Shaw's Northgate Plaza - Expand

June 15, 2000

re: Shaw's Northgate

NORTHGATE PLAZA EXPANSION
VICINITY OF 91 AUBURN STREET
SITE PLAN REVIEW
SHAW'S SUPERMARKETS, INC., APPLICANT

CATCHBASIN

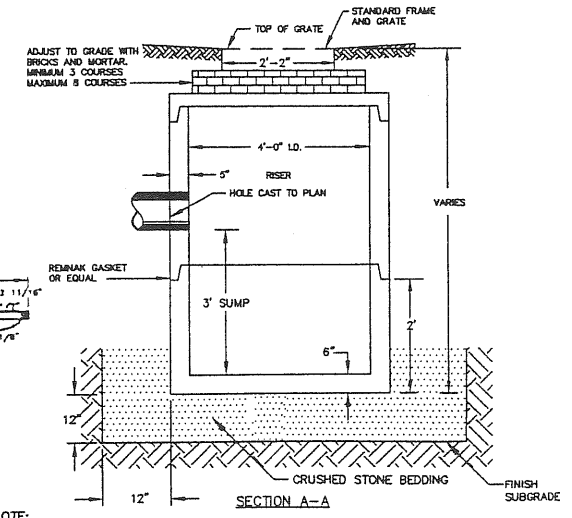
- That the applicant shall revise their plans prior to issuance of a building permit to reflect the installation of Casco traps or equivalent into all of the catchbasins outletting into the Fall Brook sewer easement. Detail sheets should also be revised to indicate a construction detail for the devices.

OVERALL SITE PLAN

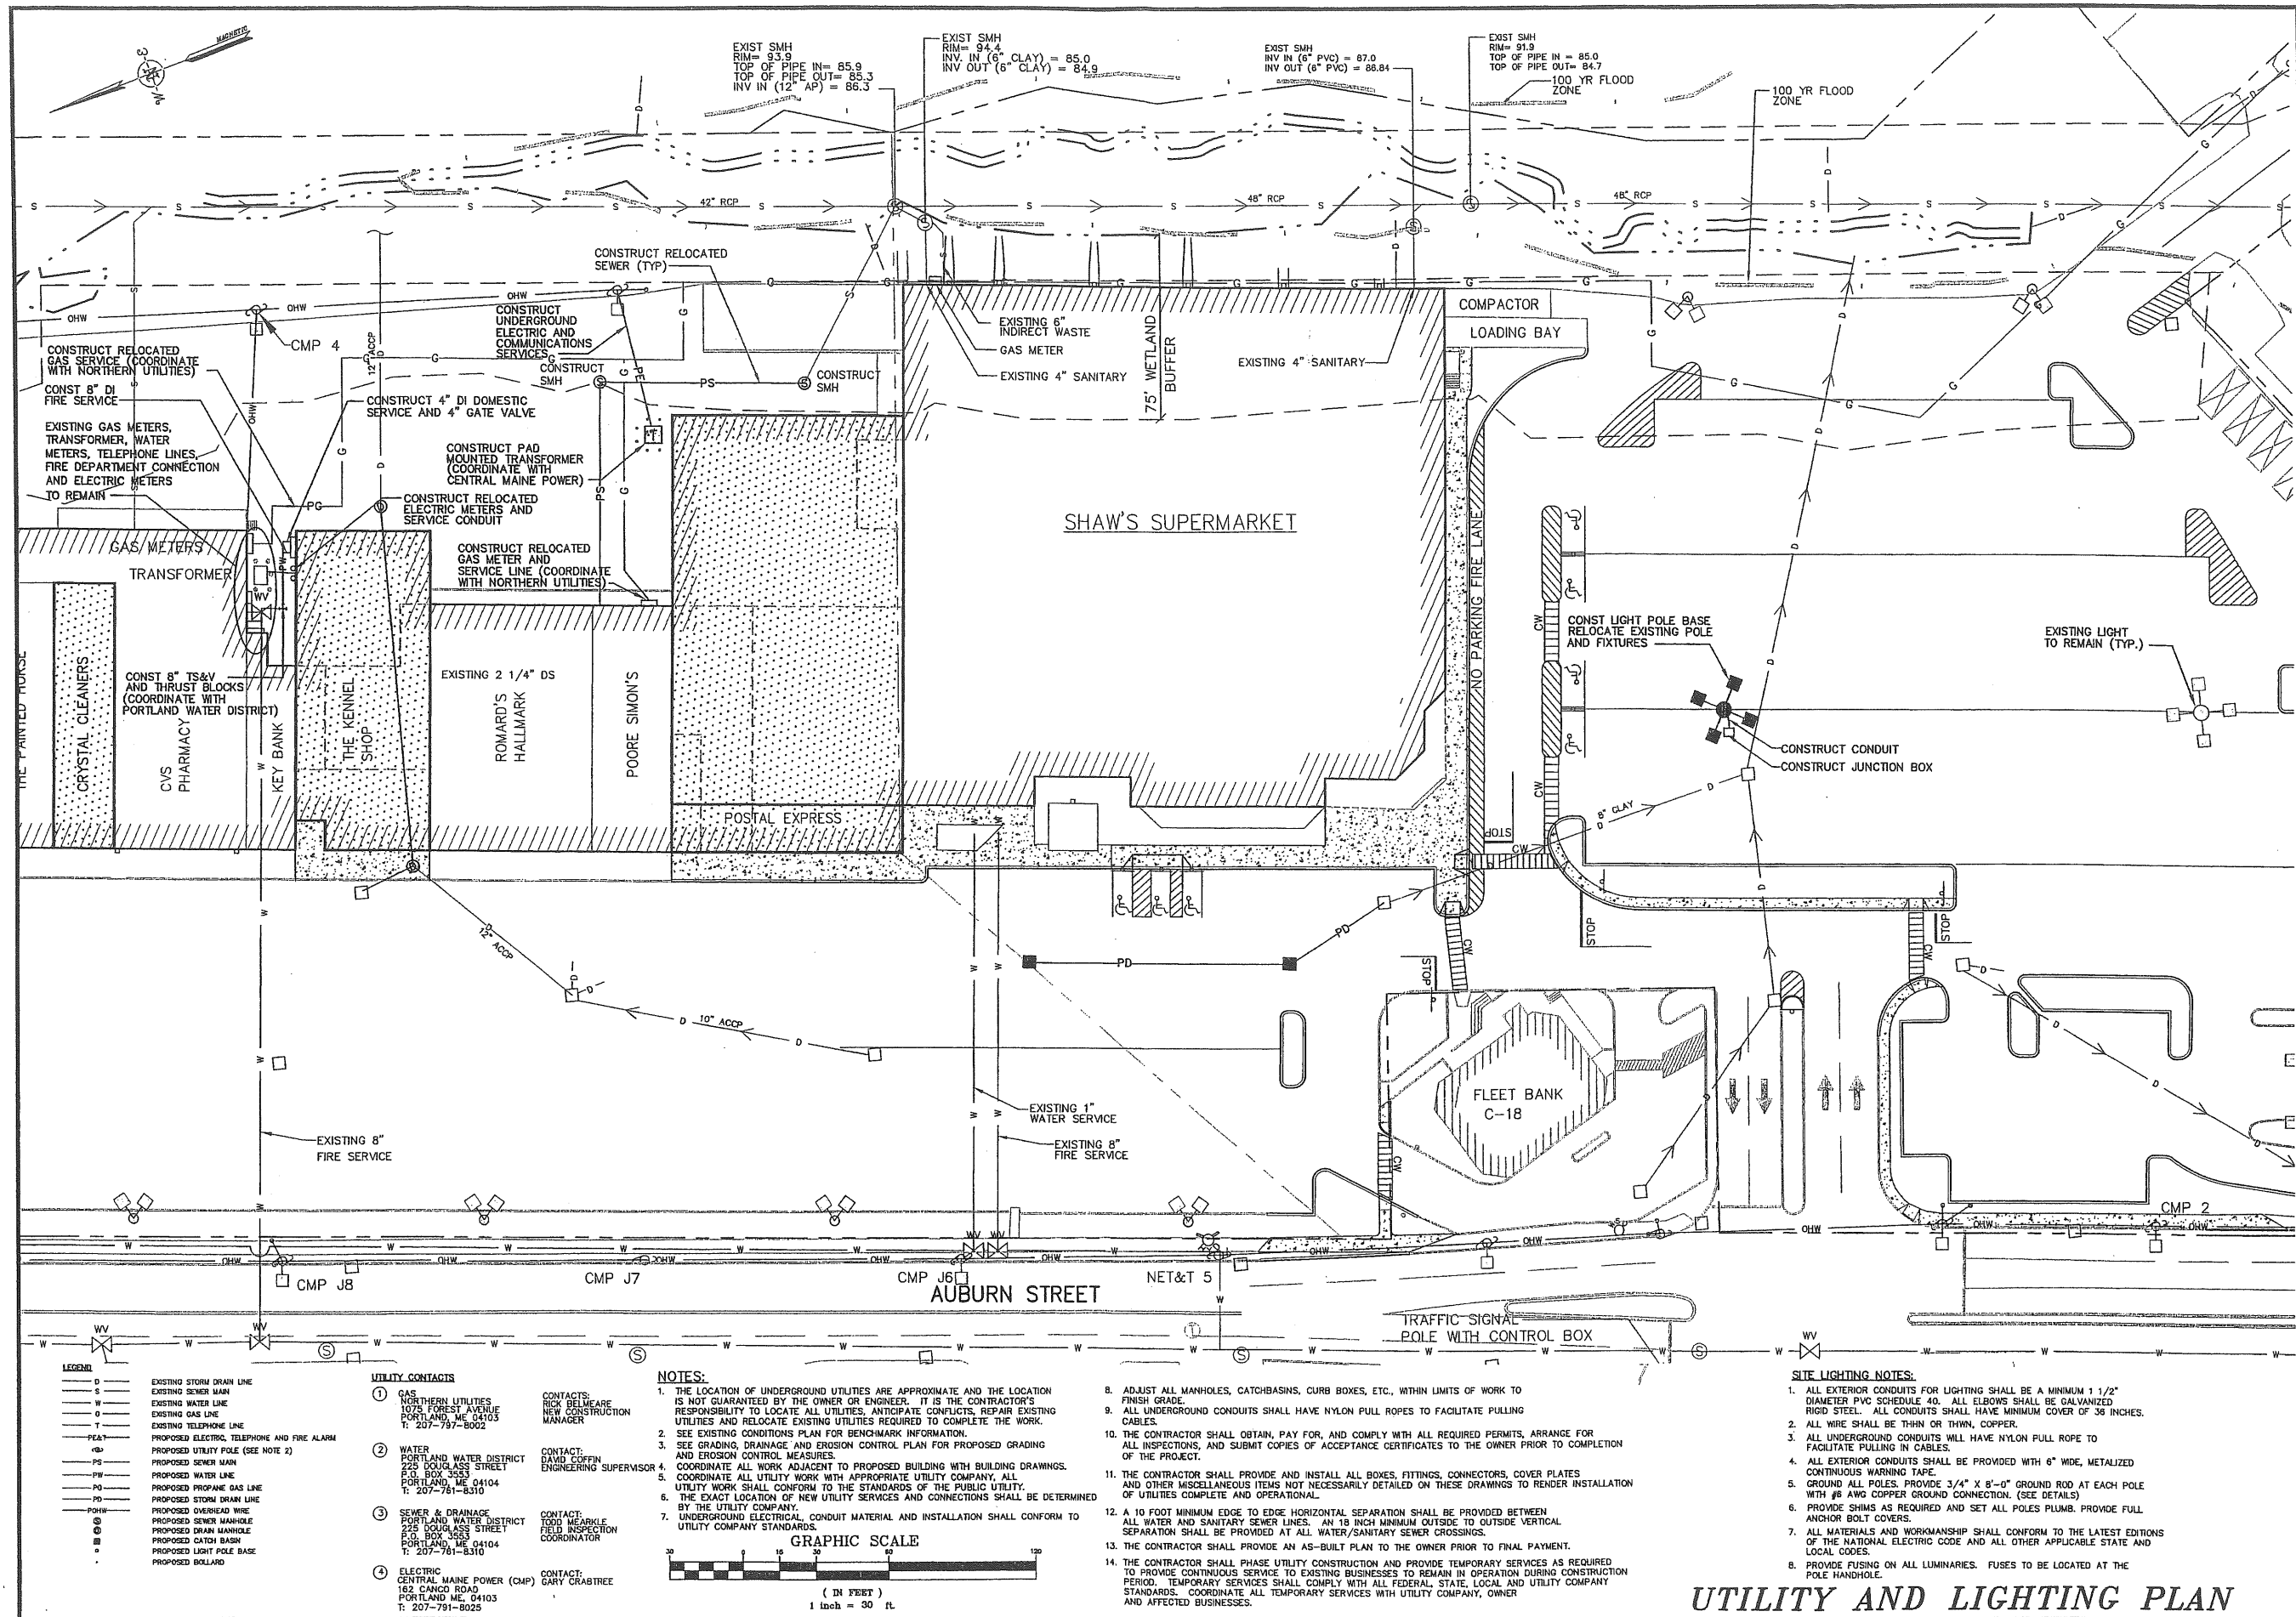
Since the last workshop with the Planning Board, the applicant has revised the plans to show a sidewalk connecting the plaza to the existing Allen Avenue sidewalk. This sidewalk would be constructed on City-owned land (Fire Station) and would therefore require a City license and indemnity agreement. These agreements have been drafted by Corporation Counsel and are included as Attachment 6.

- prior to issuance of a building permit, the applicant shall submit an executed license and indemnity agreement for construction of the Allen Avenue connecting sidewalk on City property.

UTILITY AND LIGHTING PLAN

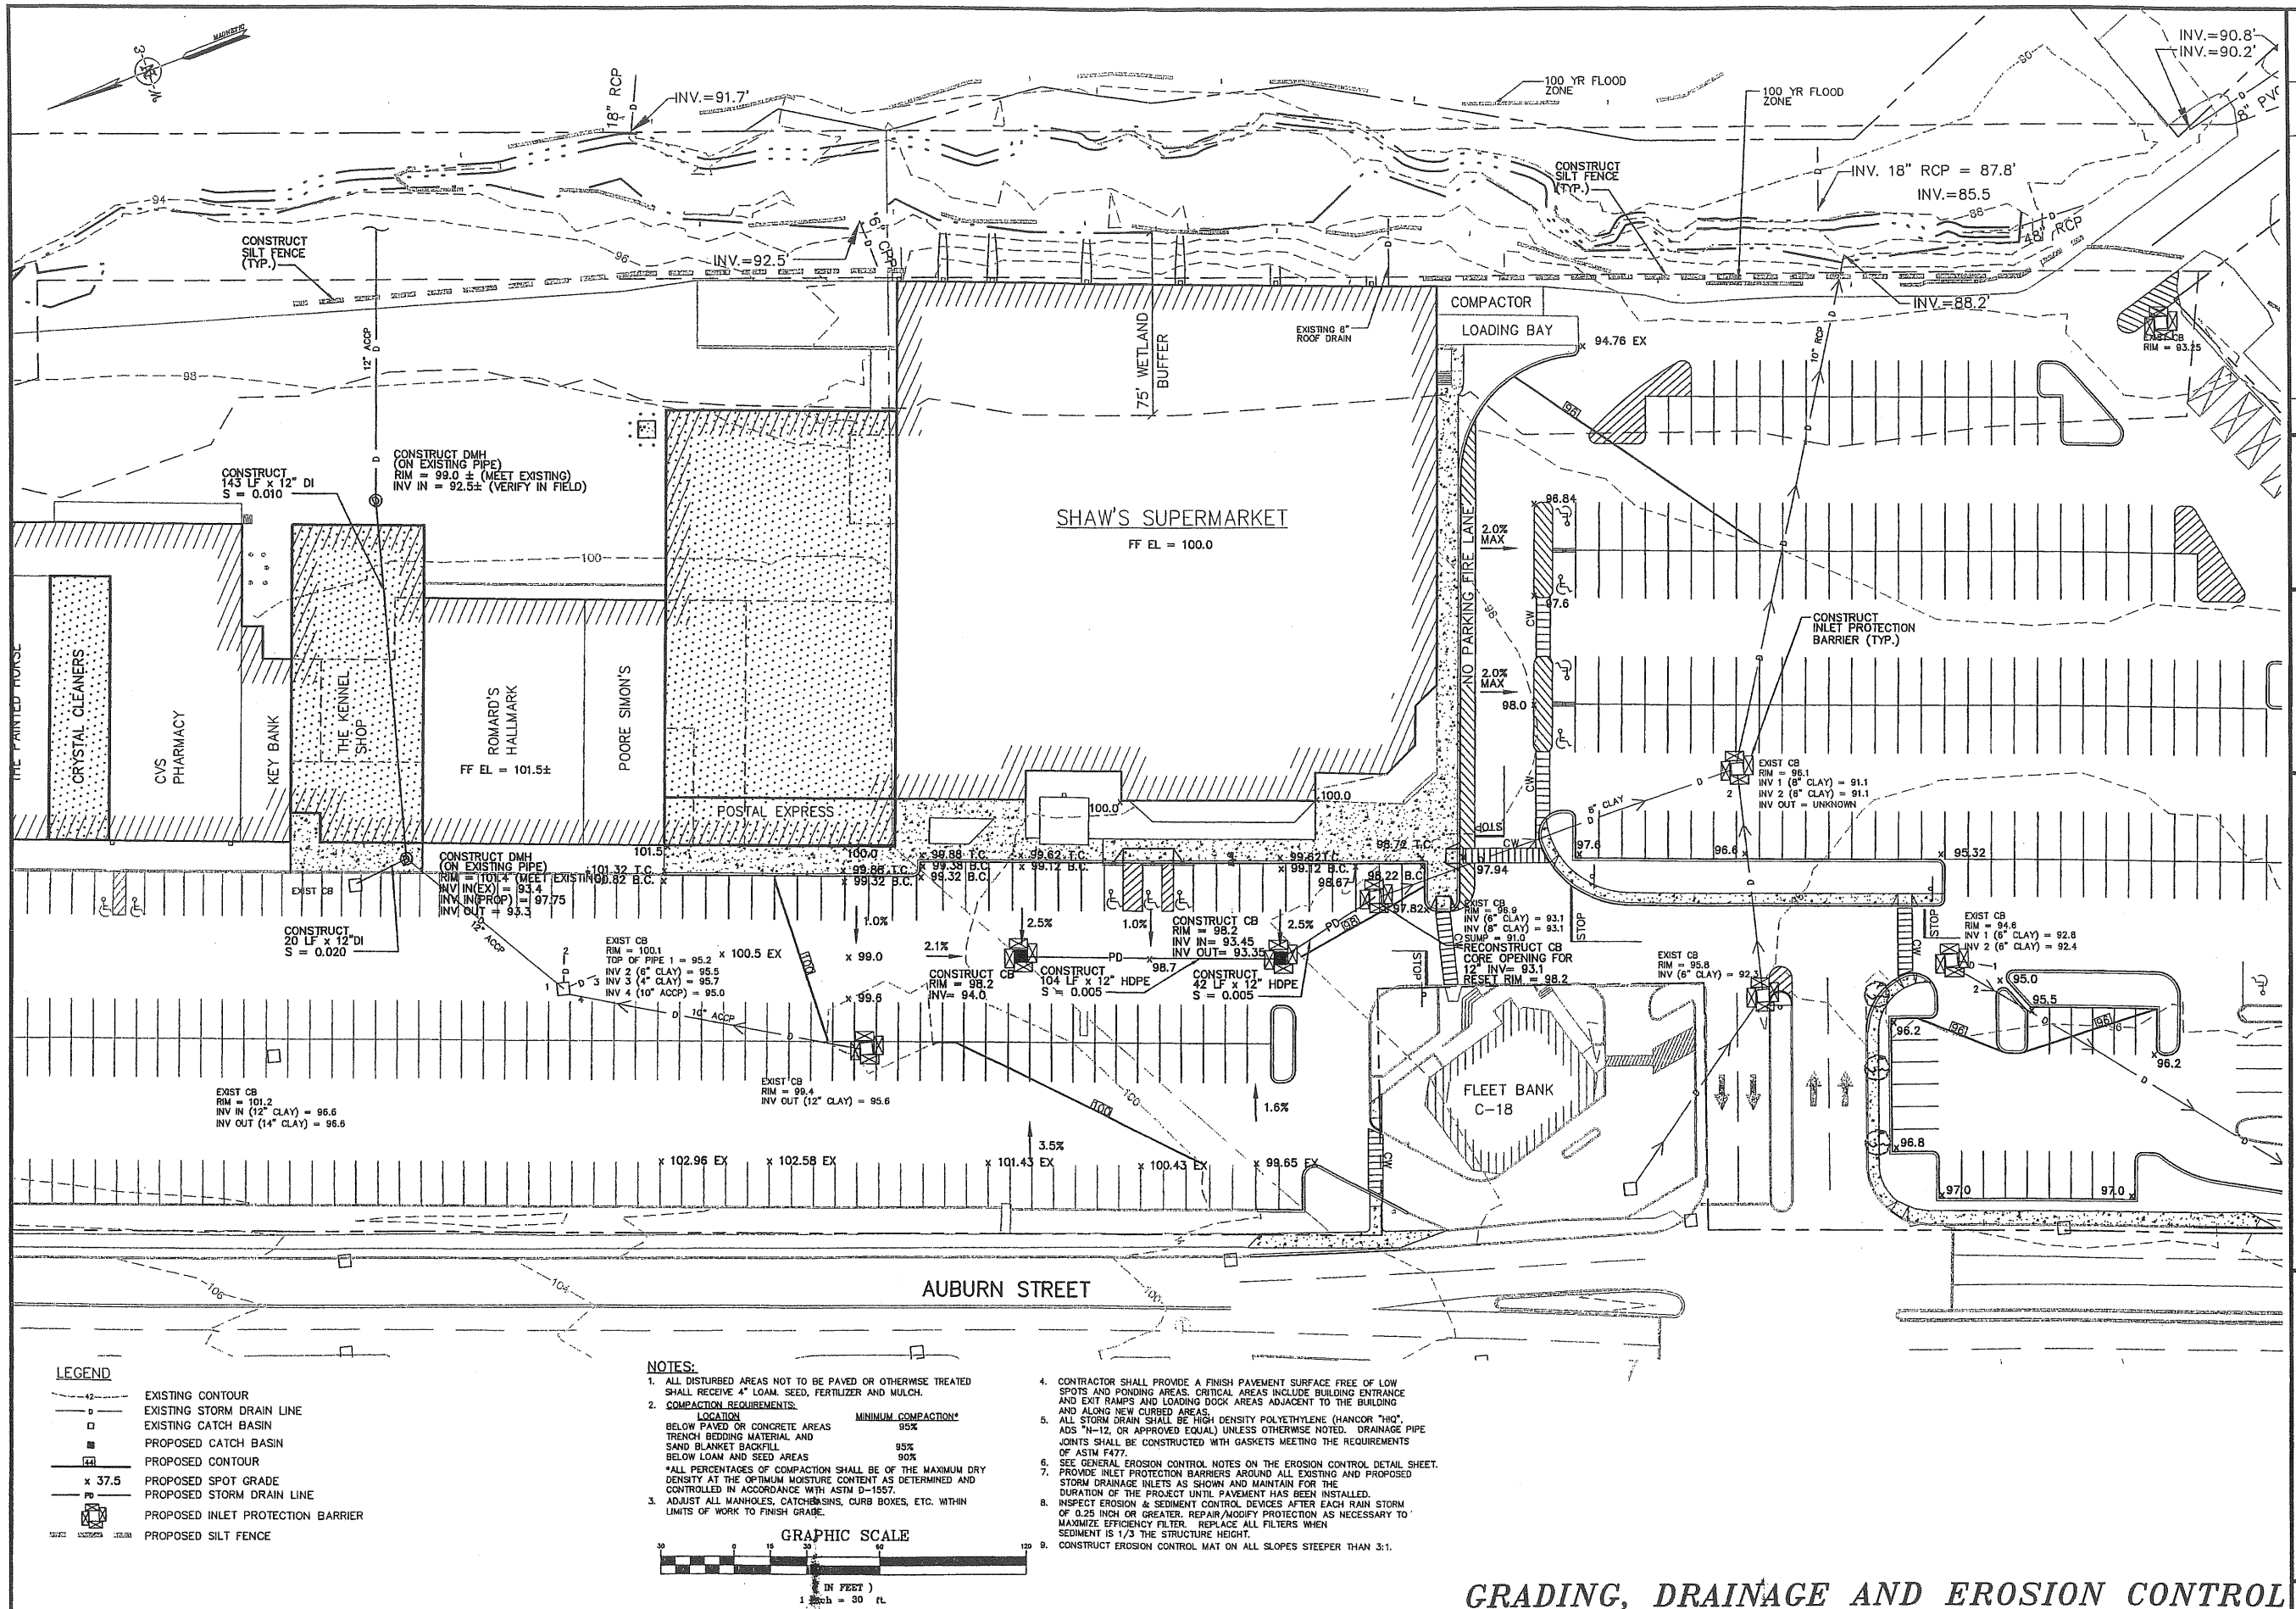
The applicant has submitted a revised lighting plan. Existing fixtures will be replaced to provide lower footcandles and less spillover onto Auburn Street and adjacent residential properties.
